Sofia Offshore Wind Farm

Annex B – Consultation with the MMO

RE: REQUEST TO INCREASE HAMMER ENERGY FOR SOFIA OFFSHORE WIND FARM (SOWF) (FORMERLY DOGGER BANK TEESSIDE A&B).

Re: Sofia Offshore Wind Farm – Non material change application to the Development Consent Order (DCO)

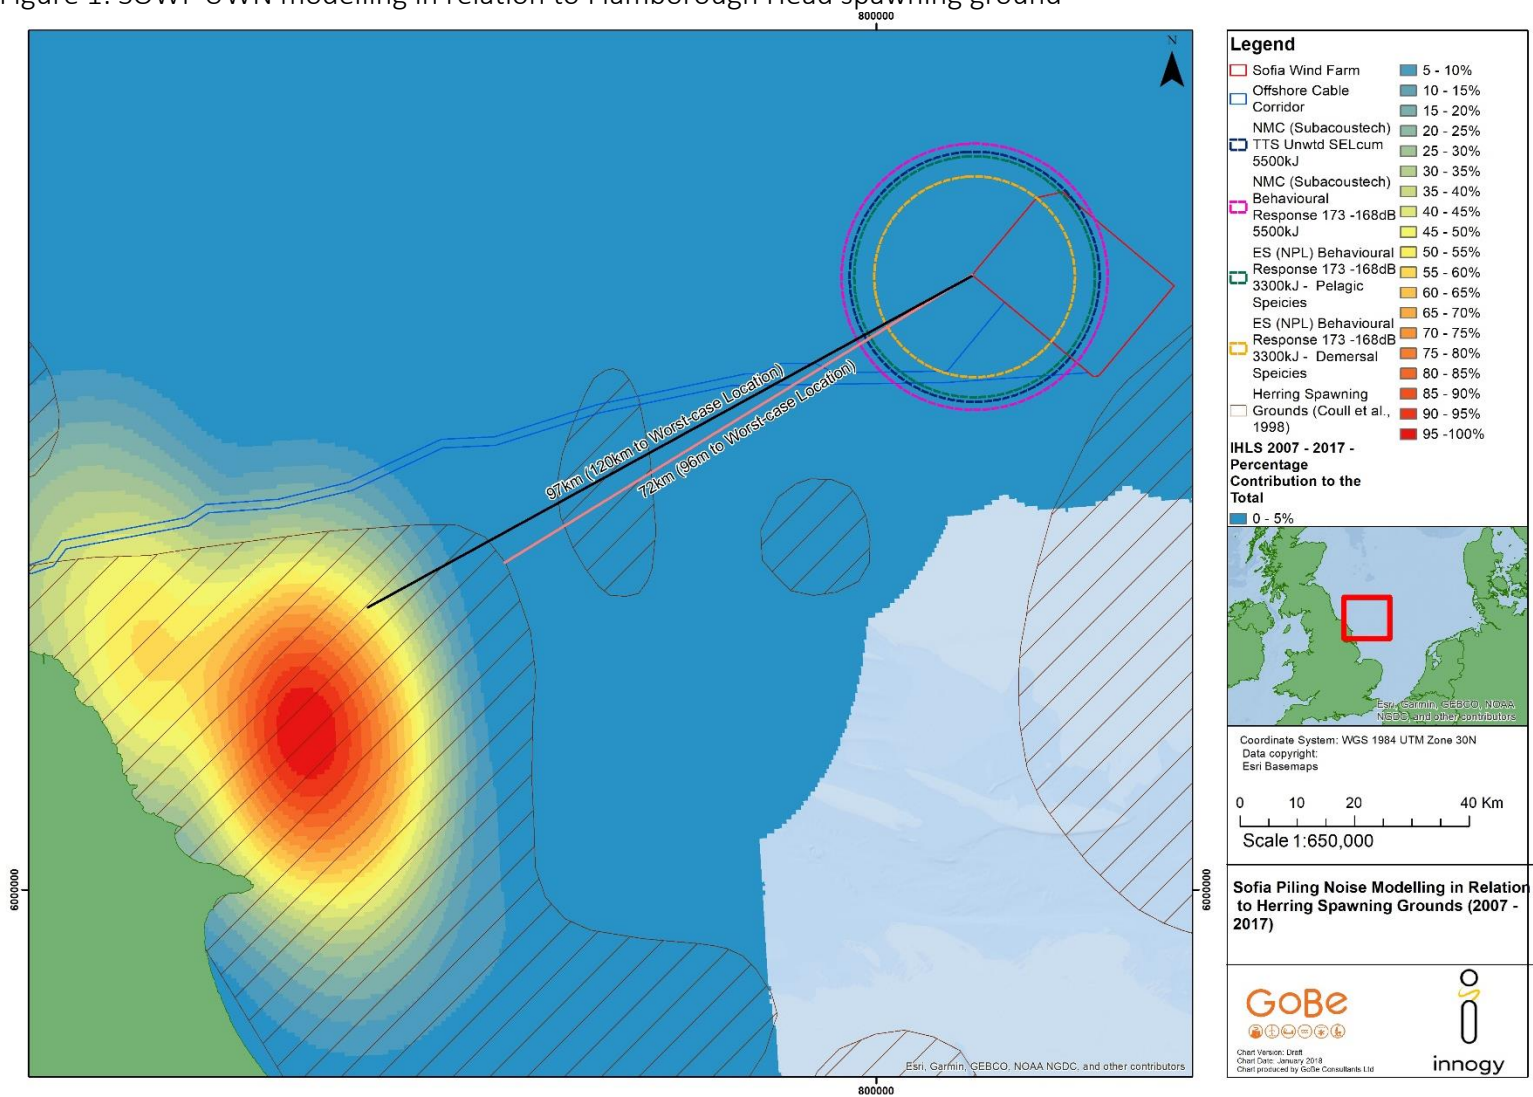
- 2.1.4. The impact ranges presented in Figure 1 of the SoCG predict that effects of noise and vibration will extend to the outer areas of broad-scale habitat for herring spawning, based on Coull *et al.* (1998).

- 2.1.6. Using the modelled data presented in Appendix A to the SoCG, the distance between the closest point of predicted impact range and the higher concentrations of herring larvae is approximately 20-30km. The MMO considers that the distance offers gravid herring and their eggs and larvae some additional buffer against potential impacts of noise at the SOWF. However, MMO also recognises that herring spawning grounds can be recolonised over time, and the exact locations for herring spawning change year on year, so there is potential for spawning activity to extend eastwards towards SOWF.
